Our Ref: EN030002

**Planning Act 2008 (as amended) and The Infrastructure Planning
(Examination Procedure) Rules 2010 (as amended) – Rule 8(3) and Rule 17**

**Application by Keuper Gas Storage Limited for an Order Granting
Development Consent for the Keuper Gas Storage Project**

Changes to the original application

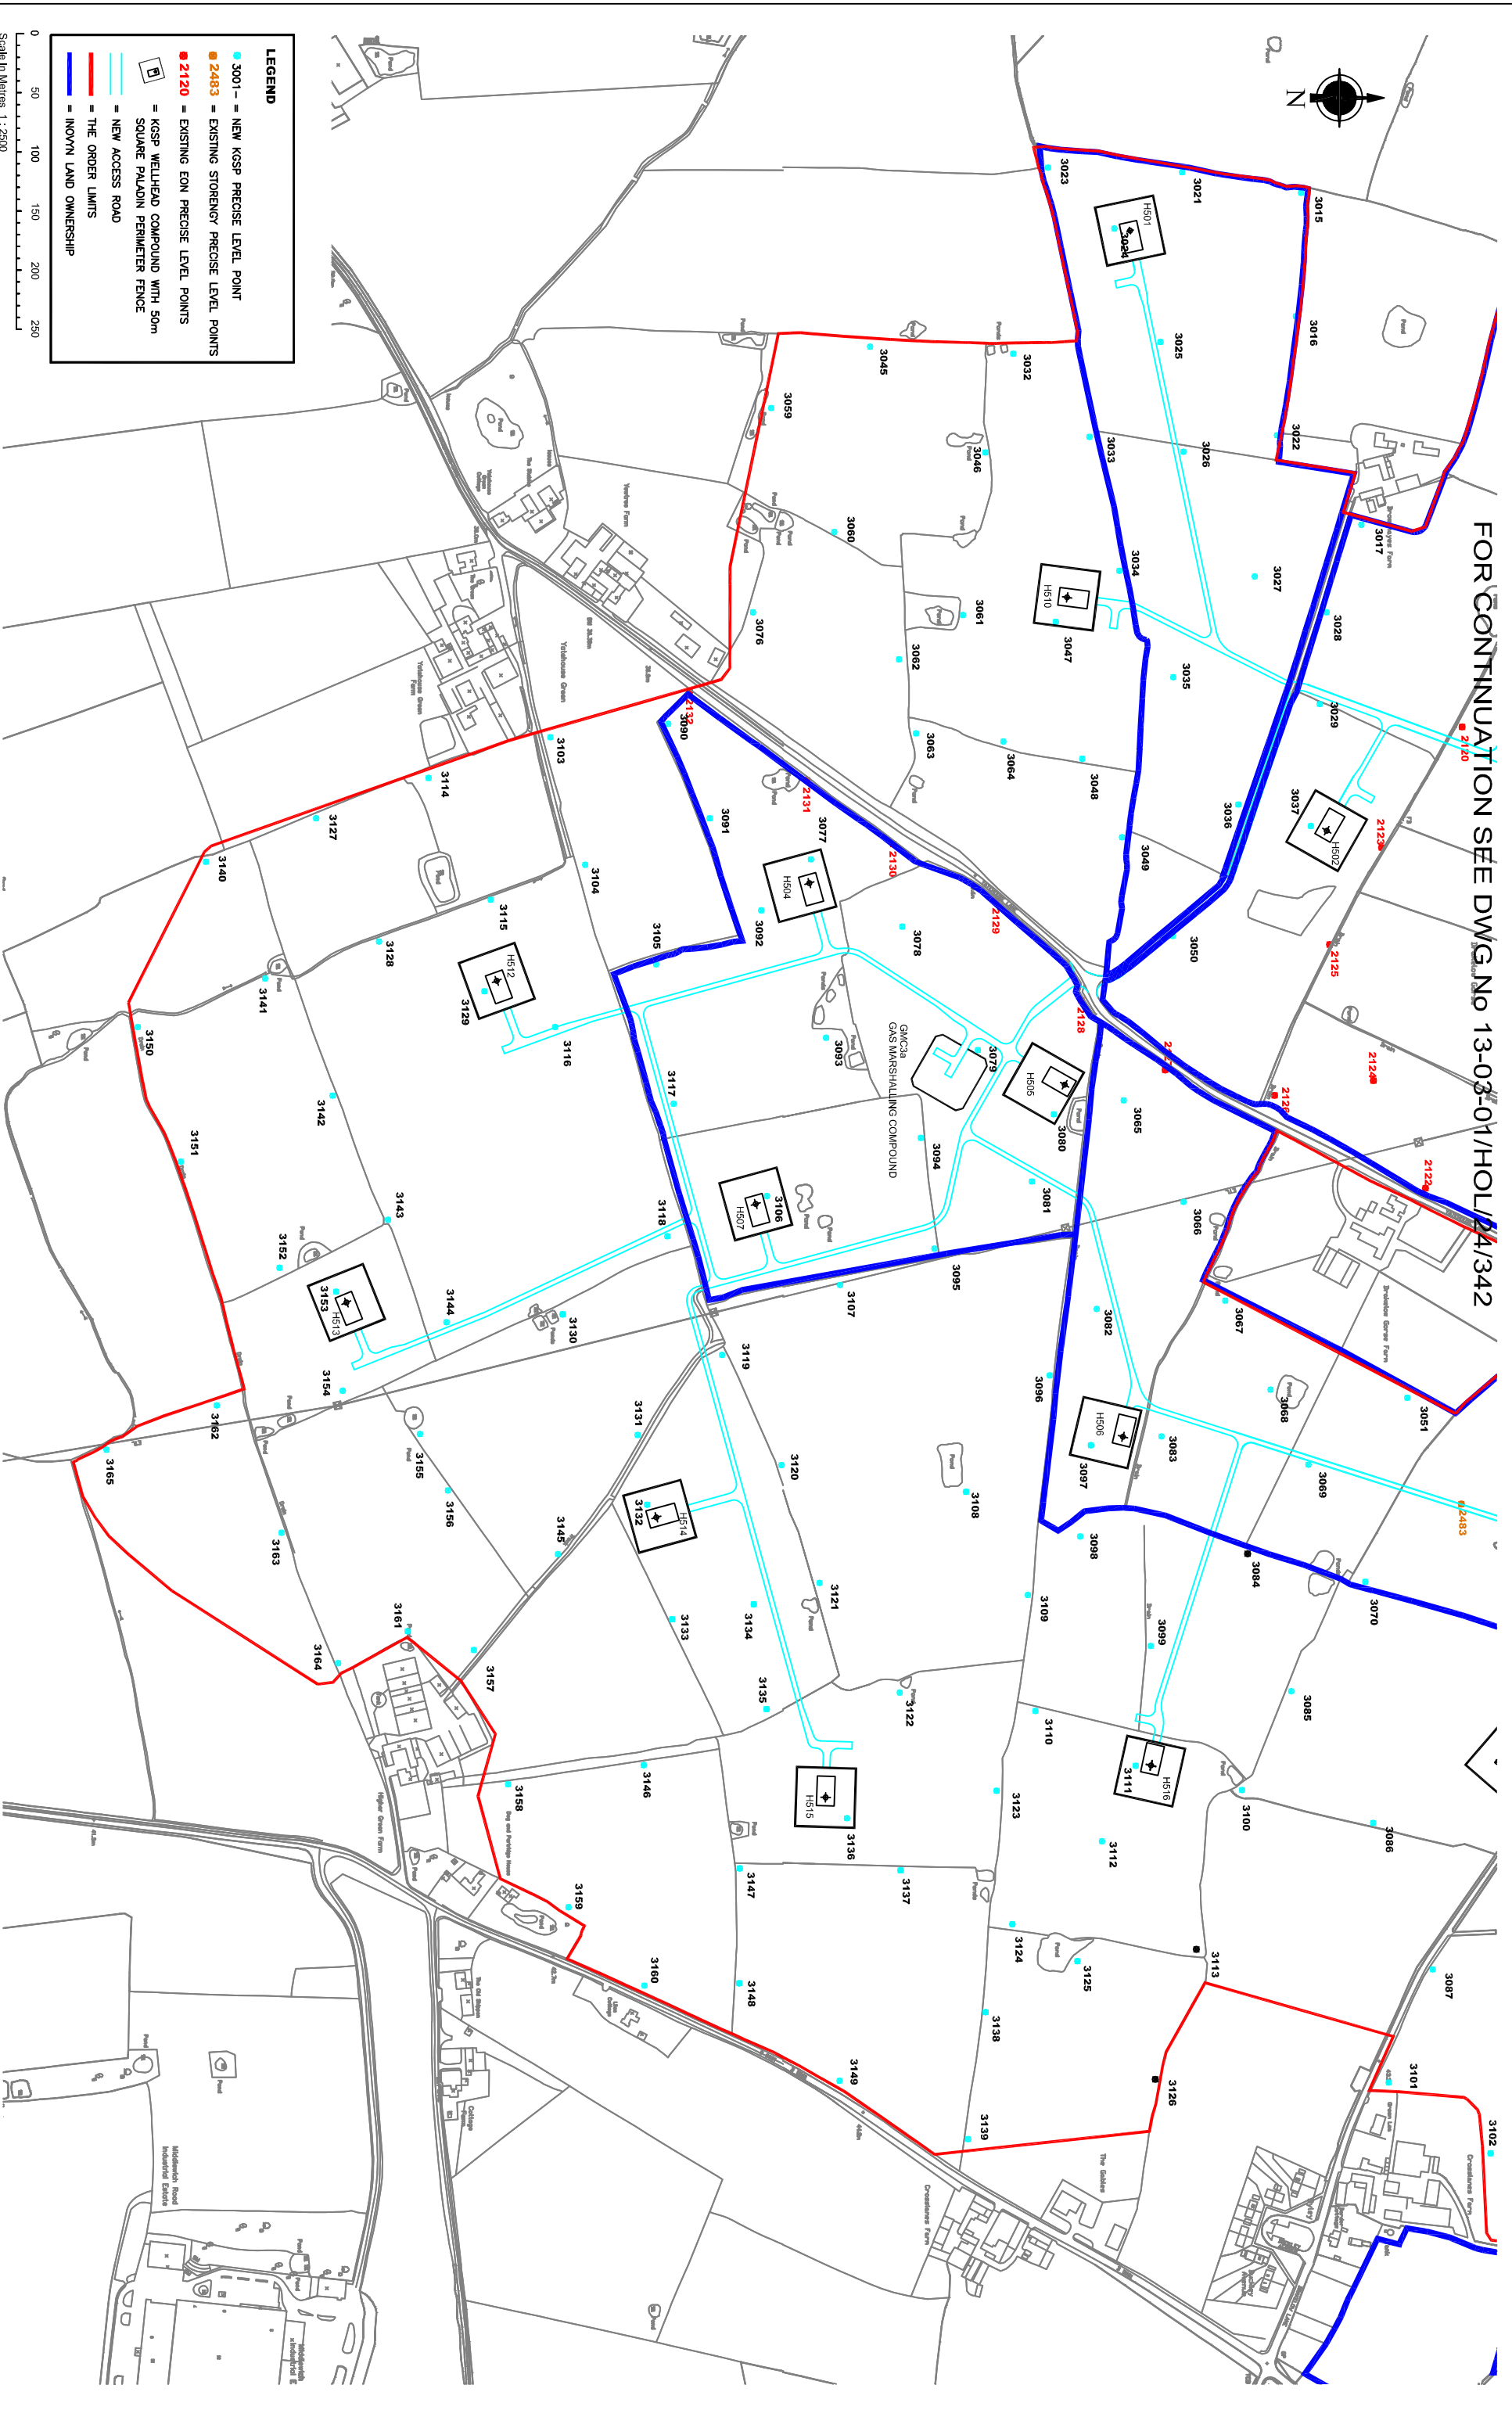
On 30 June 2016 the applicant submitted details of a variation to its original application. The proposed change relates to a move of two precise level points at Yew Tree Farm. Details of this change can be viewed on the National Infrastructure Planning website and can be accessed through the following links:

<https://infrastructure.planninginspectorate.gov.uk/document/EN030002-001096>

I have considered the material submitted by the applicant. I note that the changes are within the order limits and are made at the request of one of the landowners affected by the proposed development. I have concluded that the proposed changes to the scheme are not 'material' in the sense that accepting them would be likely to result in prejudice to any party. Given this, and having regard to the fact that information on the changes has been made available to interested parties, I have concluded that the changes should be accepted for consideration in the examination as part of the proposed development.

**HOLFORD BRINEFIELD - KGSP - ABOVE GROUND
WORKS PLAN [REGULATION 5(2)(I)] - SHEET 9 OF 9**

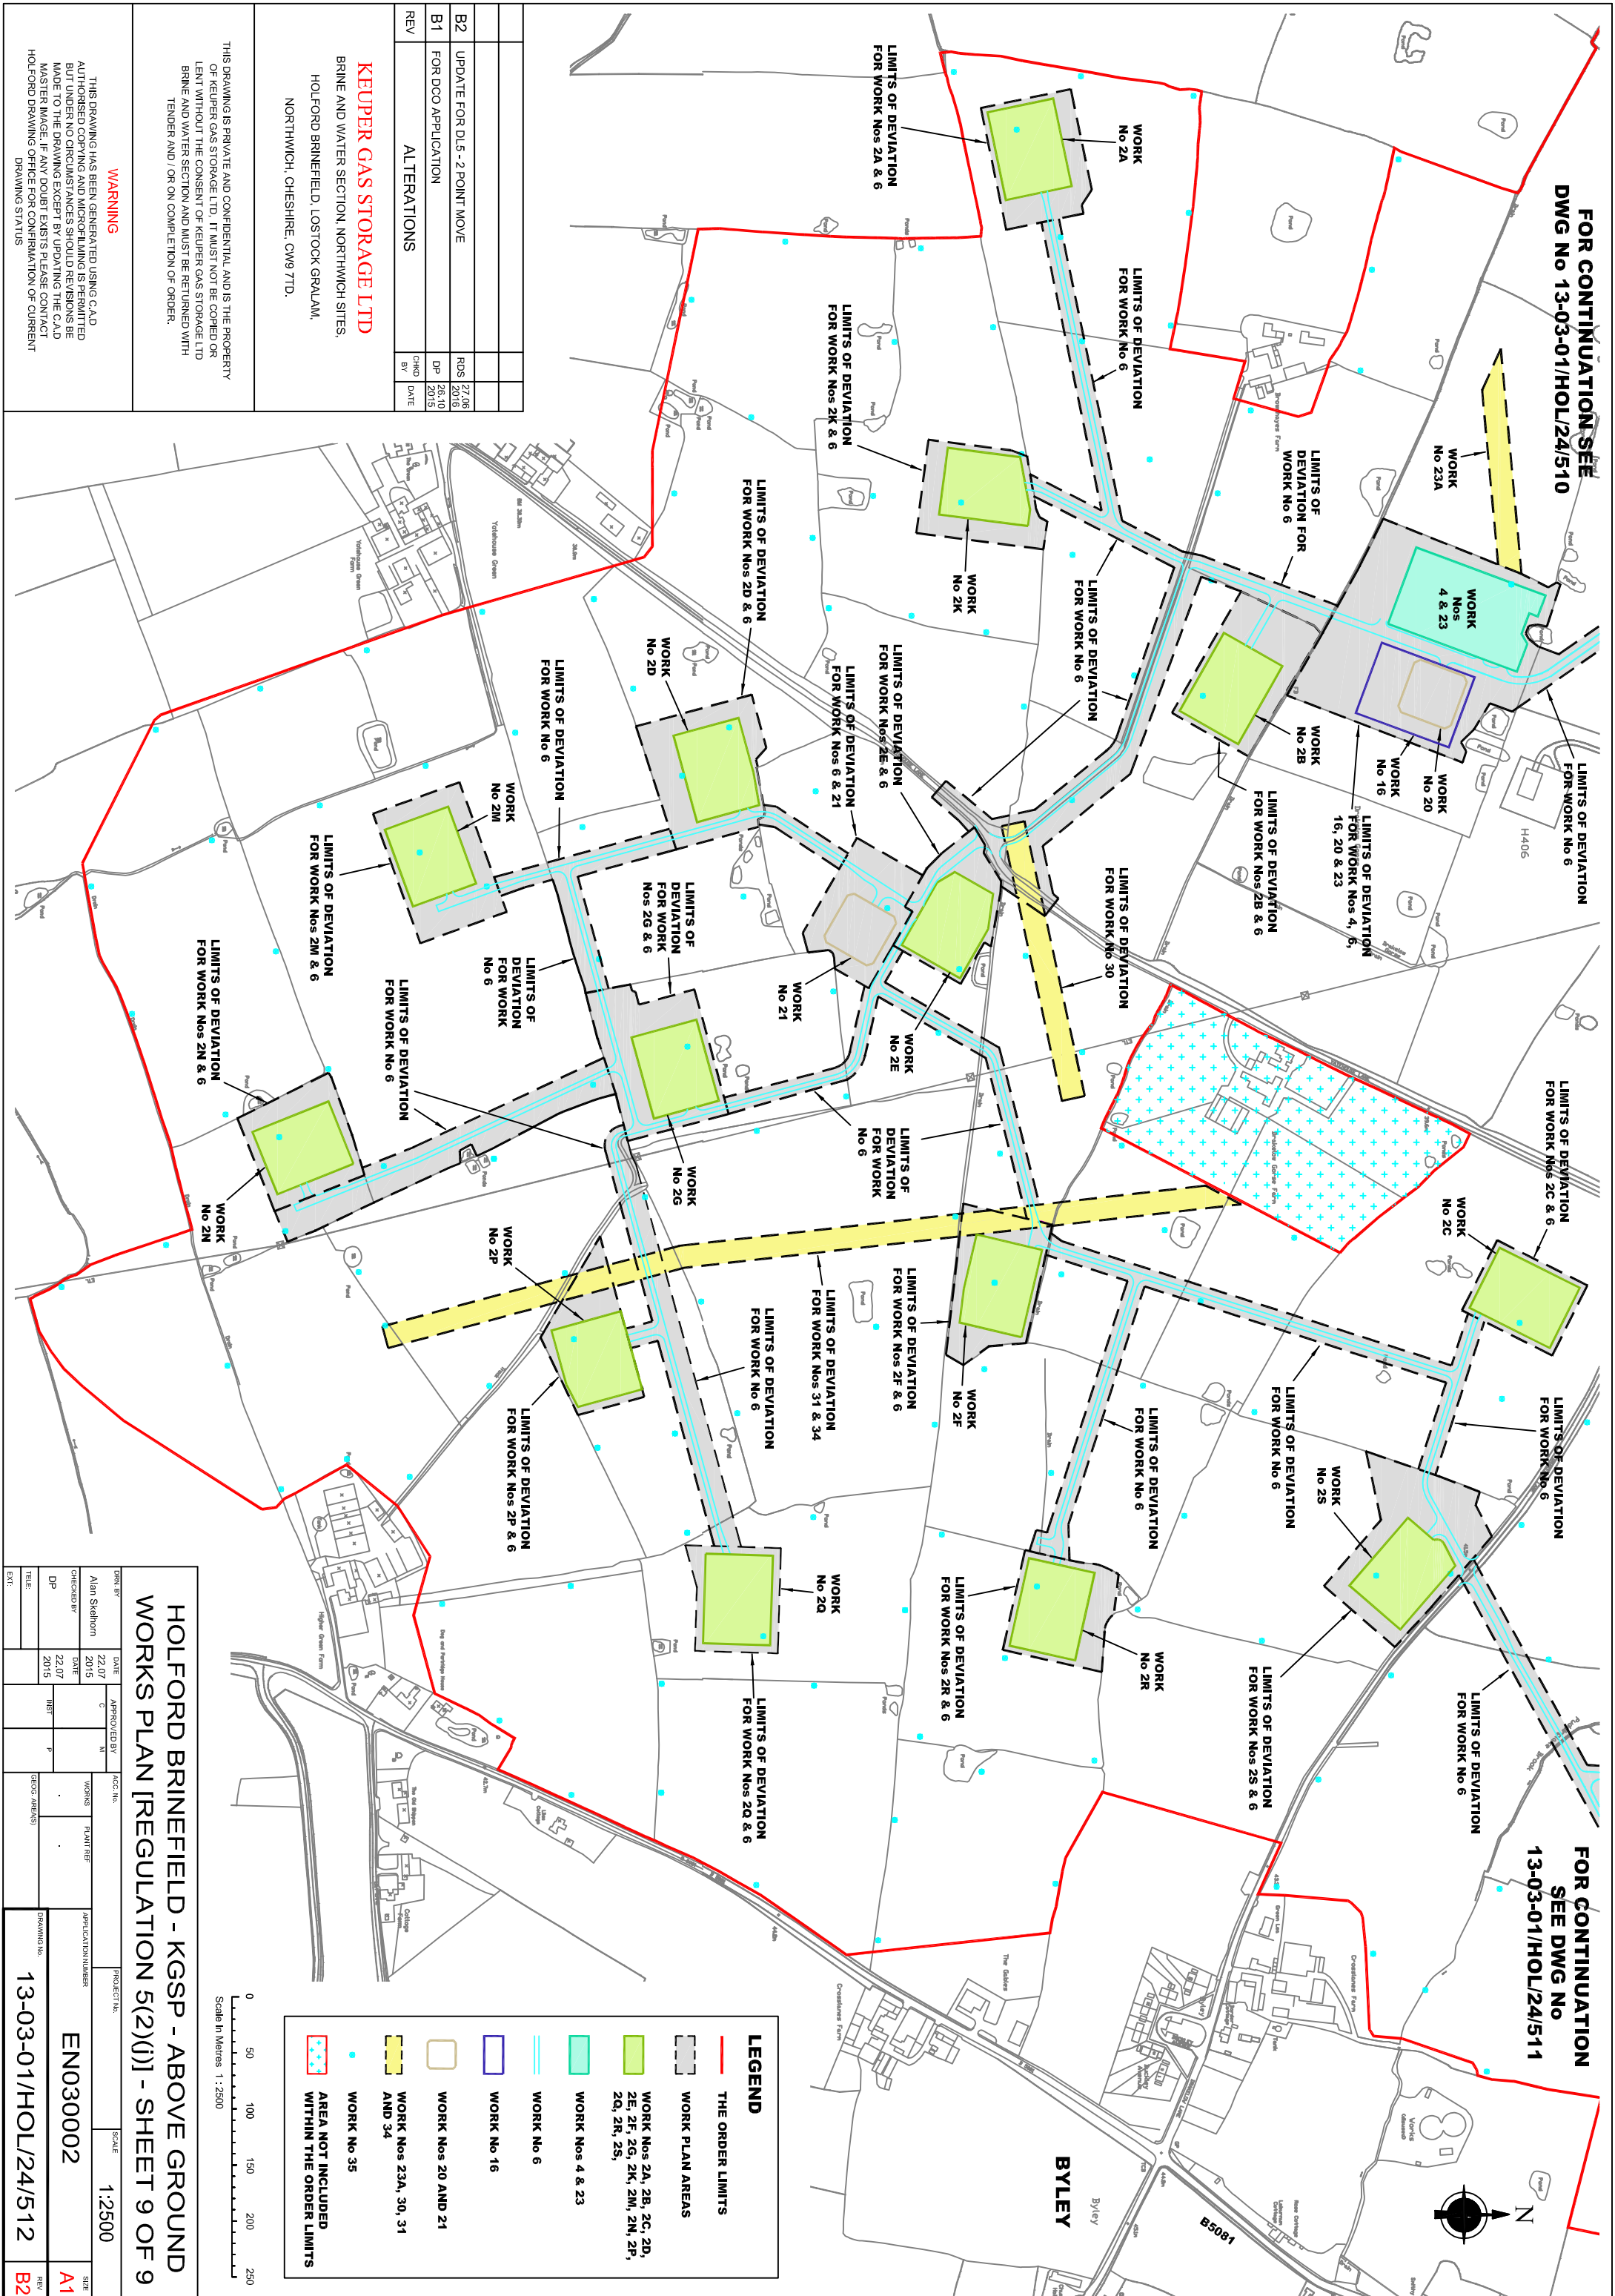
<https://infrastructure.planninginspectorate.gov.uk/document/EN030002-001097>
